# CITY OF ALBUQUERQUE

November 16, 2023

**Re: Take 5 Oil Change**  
**1125 Snow Vista Blvd. NW**  
**Traffic Circulation Layout**  
Engineer's Stamp 11-03-23 (M09-D012C)

Job Number	23007	Sheet	C2.0
------------	-------	-------	------

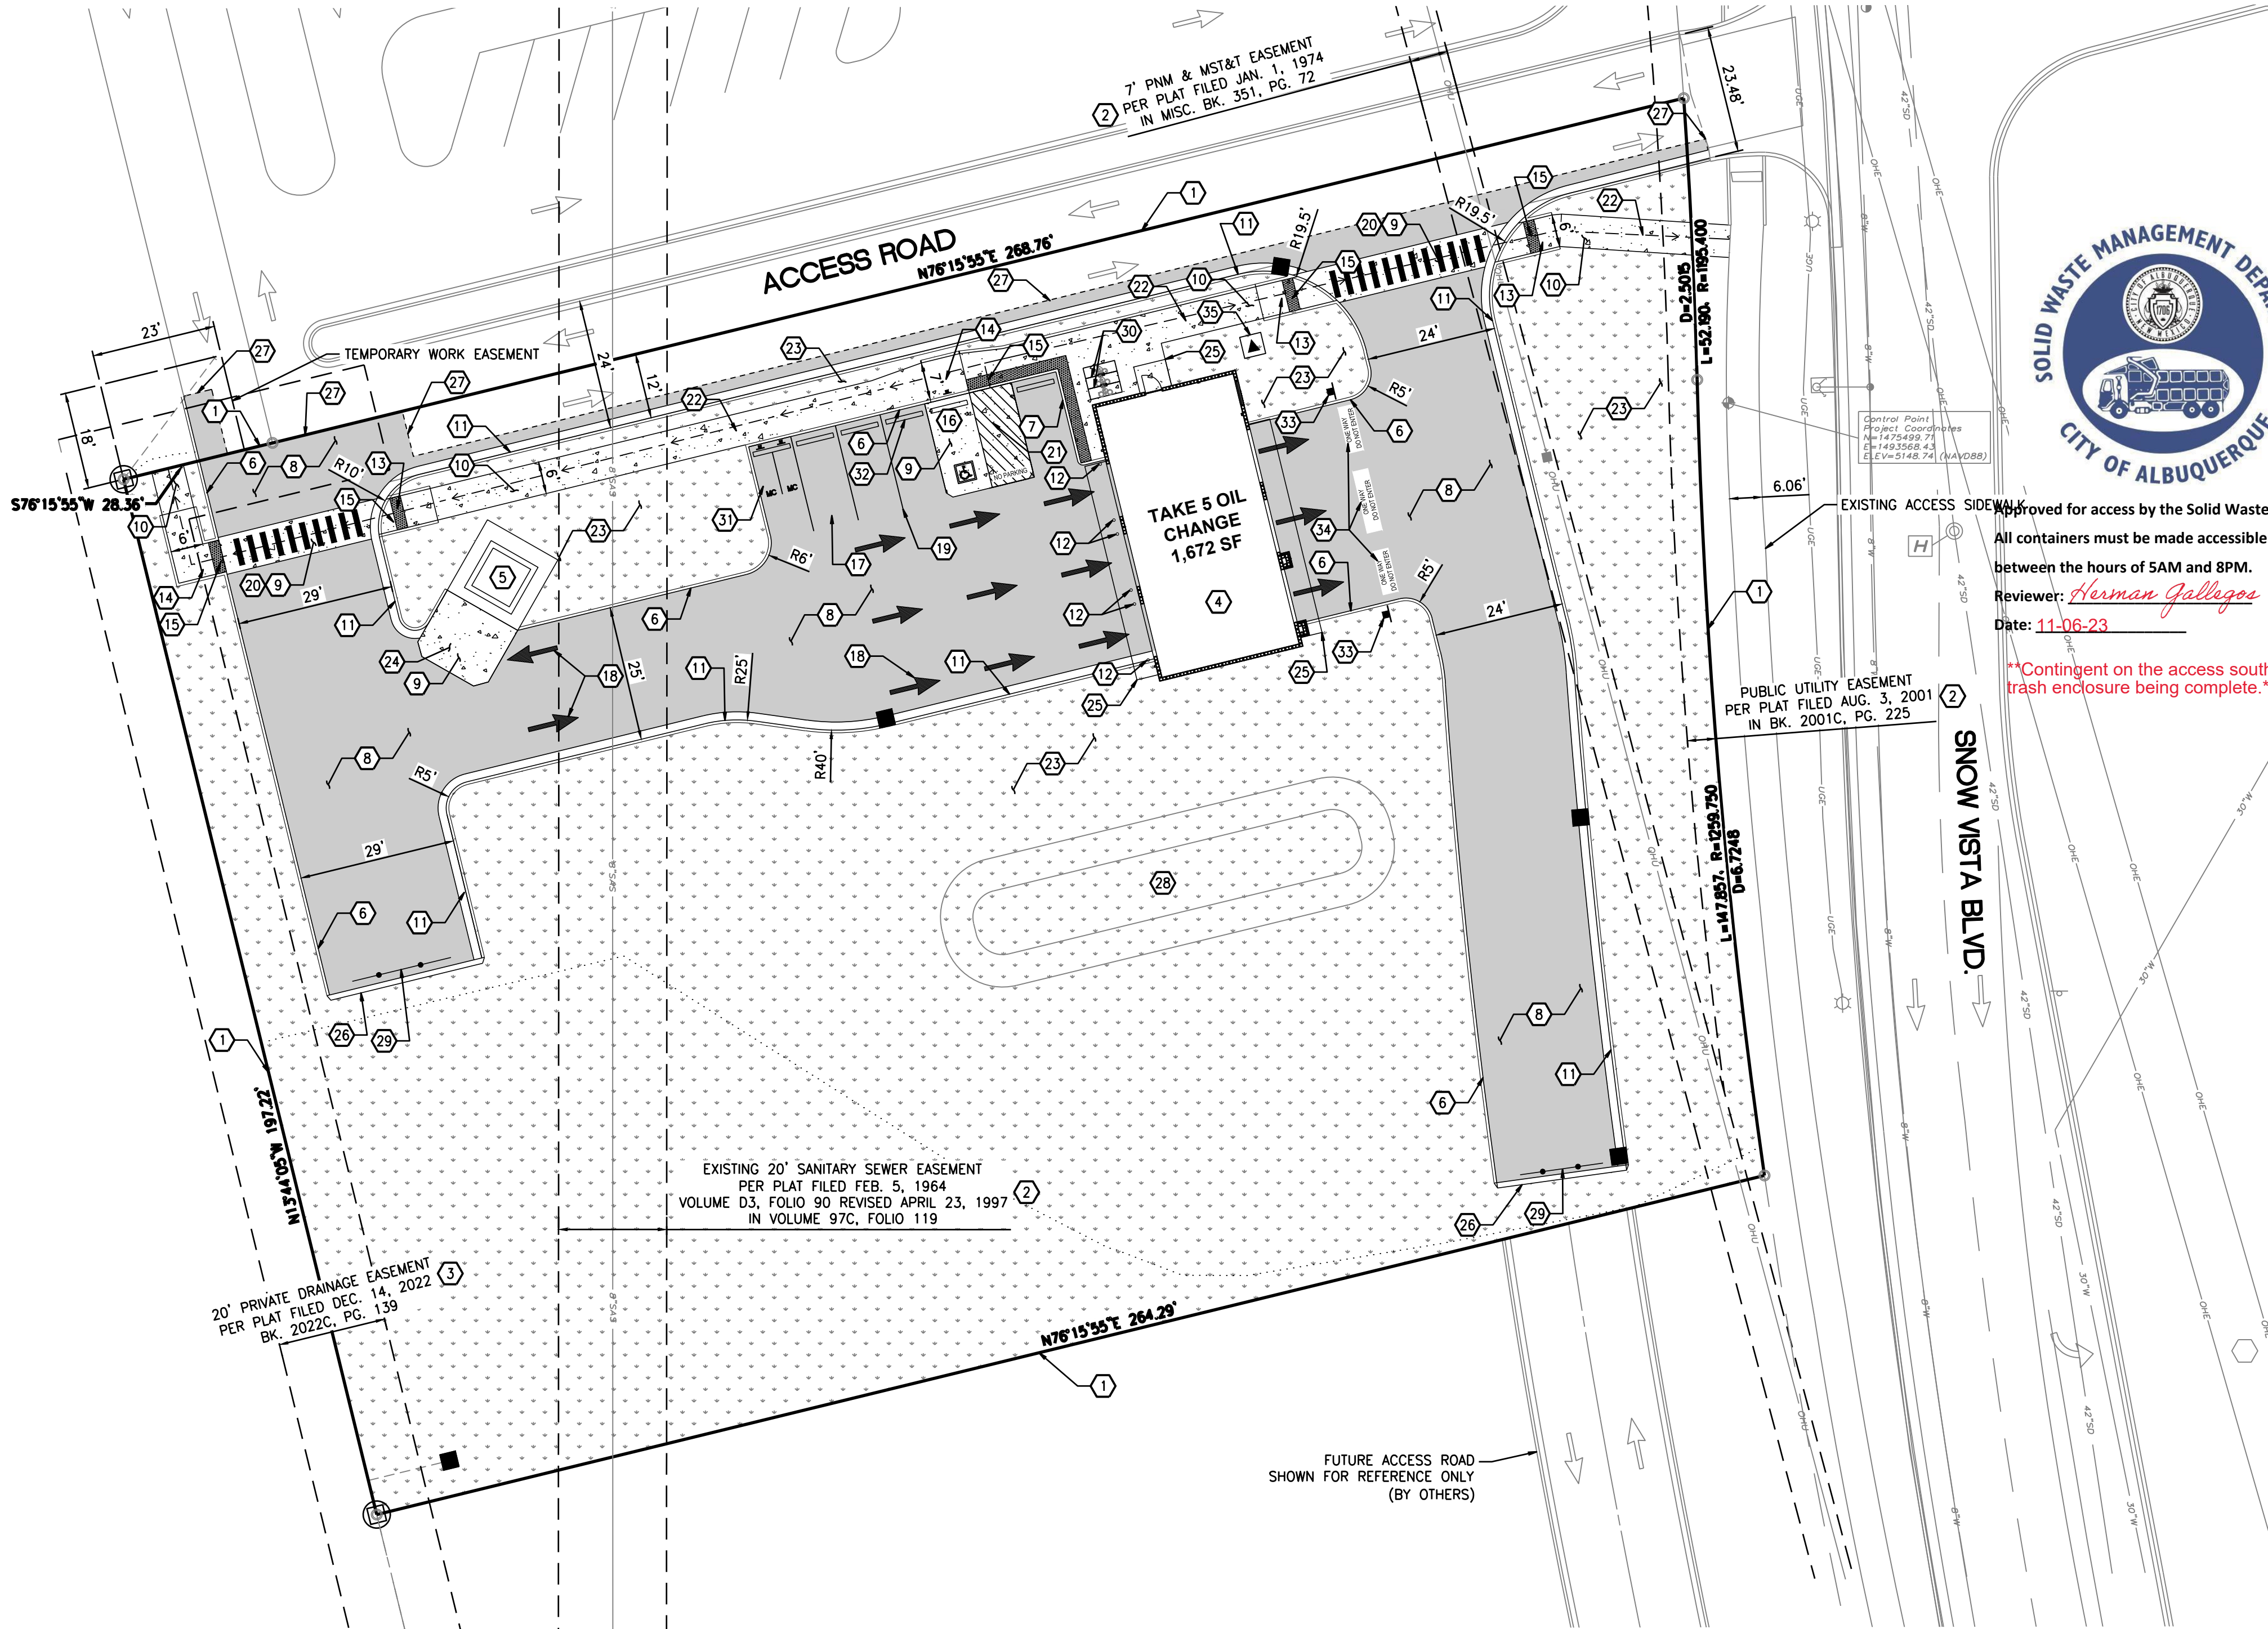
When the site construction is completed and an inspection for Certificate of Occupancy (C.O.) is requested, use the original City stamped approved TCL for certification. Redline any minor changes and adjustments that were made in the field. A NM registered architect or engineer must stamp, sign, and date the certification TCL along with indicating that the development was built in "substantial compliance" with the TCL. Submit this certification, the TCL, and a completed Drainage and Transportation Information Sheet to the [PLNDRS@cabq.gov](mailto:PLNDRS@cabq.gov) for log in and evaluation by Transportation. **A 24 FT. WIDE ACCESS ROAD AT THE NORTH SIDE OF THE SITE, MUST BE BUILT PRIOR TO ISSUE A FINAL CO.**
